OUT18/4263

Cadia Hill Tailings Modification

The department has reviewed the modification application and provides the following recommended conditions of consent. Detailed comments are provided in Attachment A.

ATTACHMENT A – Detailed Comments

**ENCLOSURE 1**  
**FIGURES**

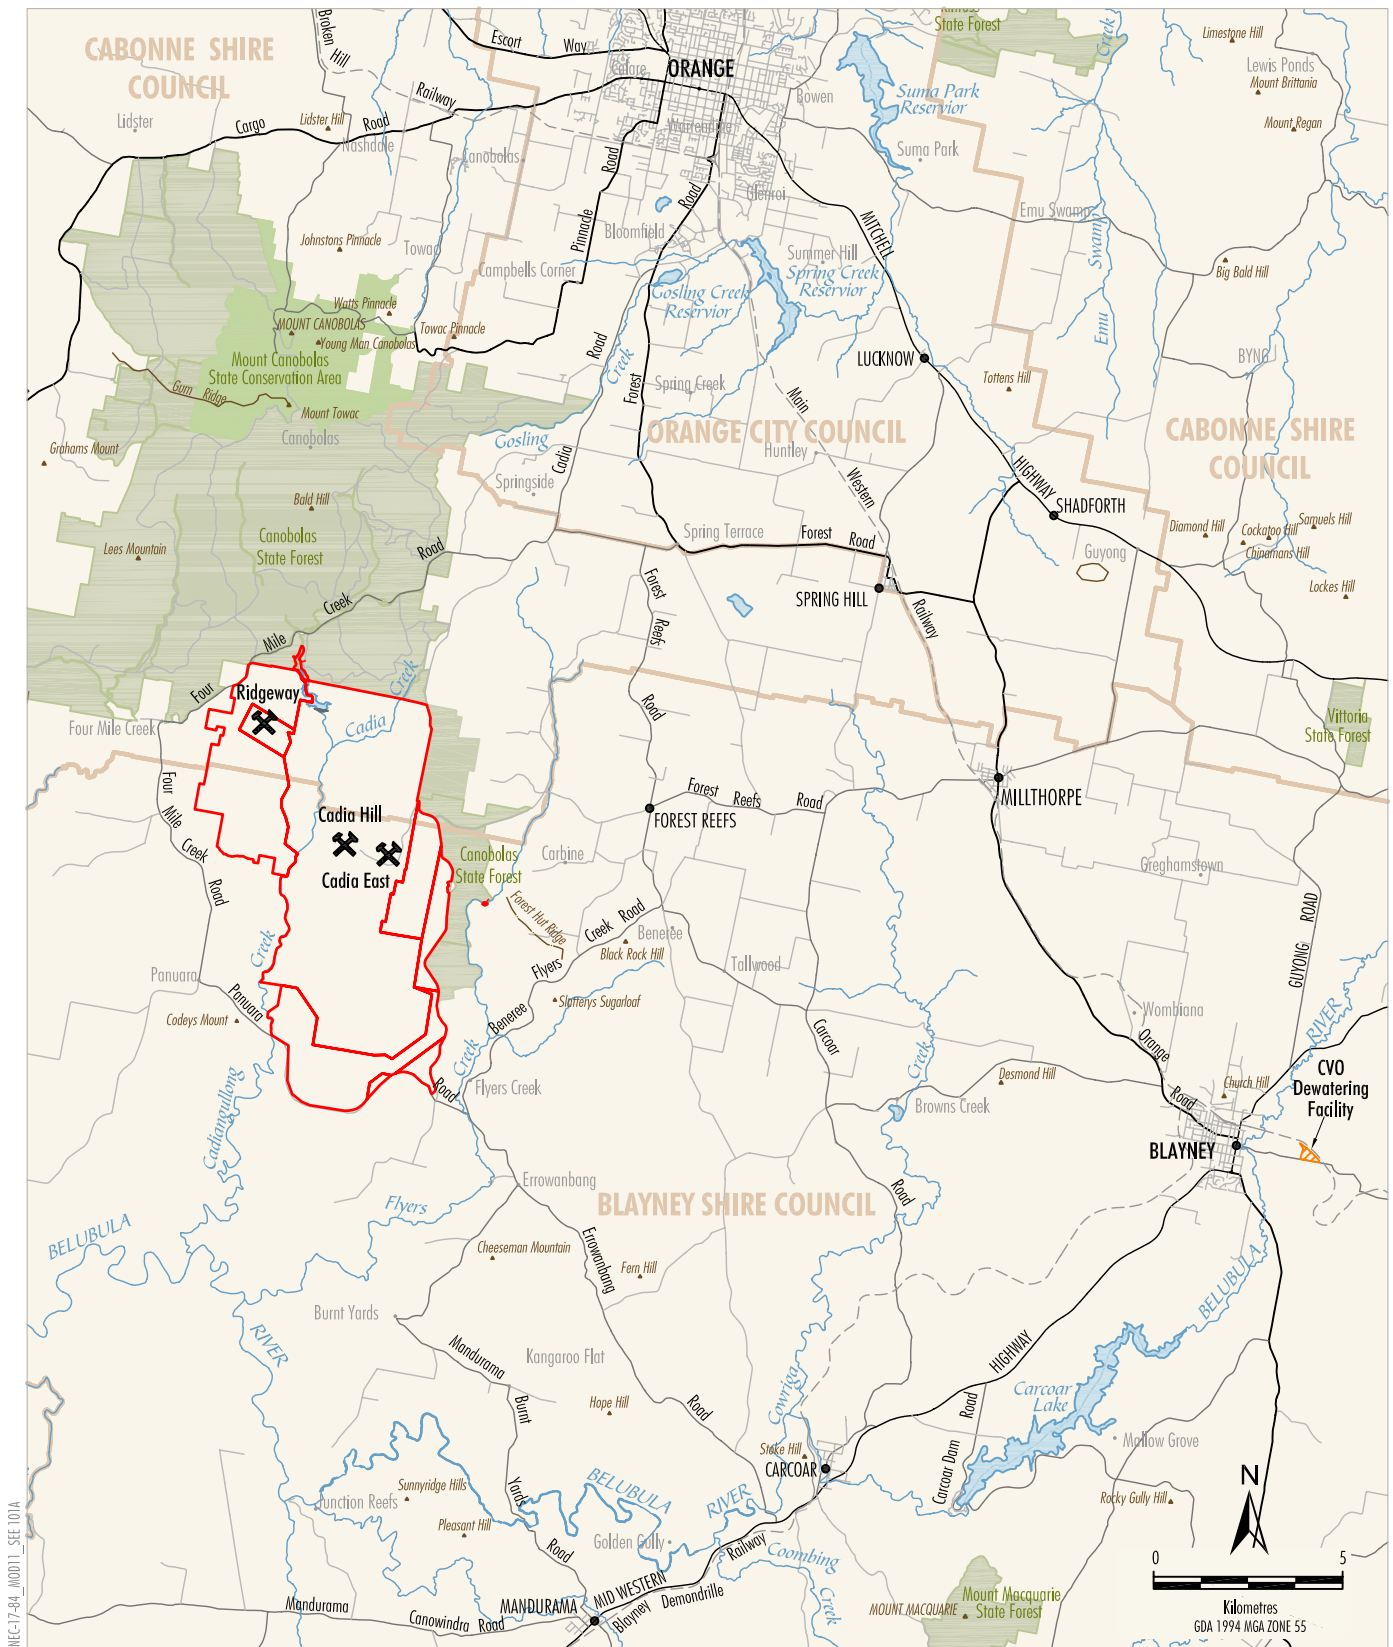
14	<p>Groundwater monitoring at the Cadia Valley Operations during the in-pit deposition of tailings at the Cadia Hill open pit would be undertaken in accordance with CHPL's existing Water Management Plan. The current groundwater monitoring programme is extensive (Figure 4 – Enclosure 1). However, CHPL would review, and where necessary revise, the number of groundwater bores proximal to the Cadia Hill open pit, to verify the ongoing hydraulic gradient towards the areas of historical and current mining. Any such monitoring improvements would be documented in a revision to the Water Management Plan.</p> <p>With some minor extensions to the existing environmental monitoring network, the Cadia Valley Operations environmental management and monitoring measures already being applied by CHPL would continue to be applied to minimise the potential impacts on existing environmental values. (CVO)</p>	<p>Acknowledged</p> <p>CVO acknowledges the need to carry out groundwater monitoring (hydrodynamics + water quality) during the in-pit deposition of tailings at Cadia Hill open pit.</p> <p>Recommendation: <i>Deep monitoring bore/s should be constructed to establish the baseline hydrodynamics and water quality of the groundwater at or near the base of the pit .</i></p>
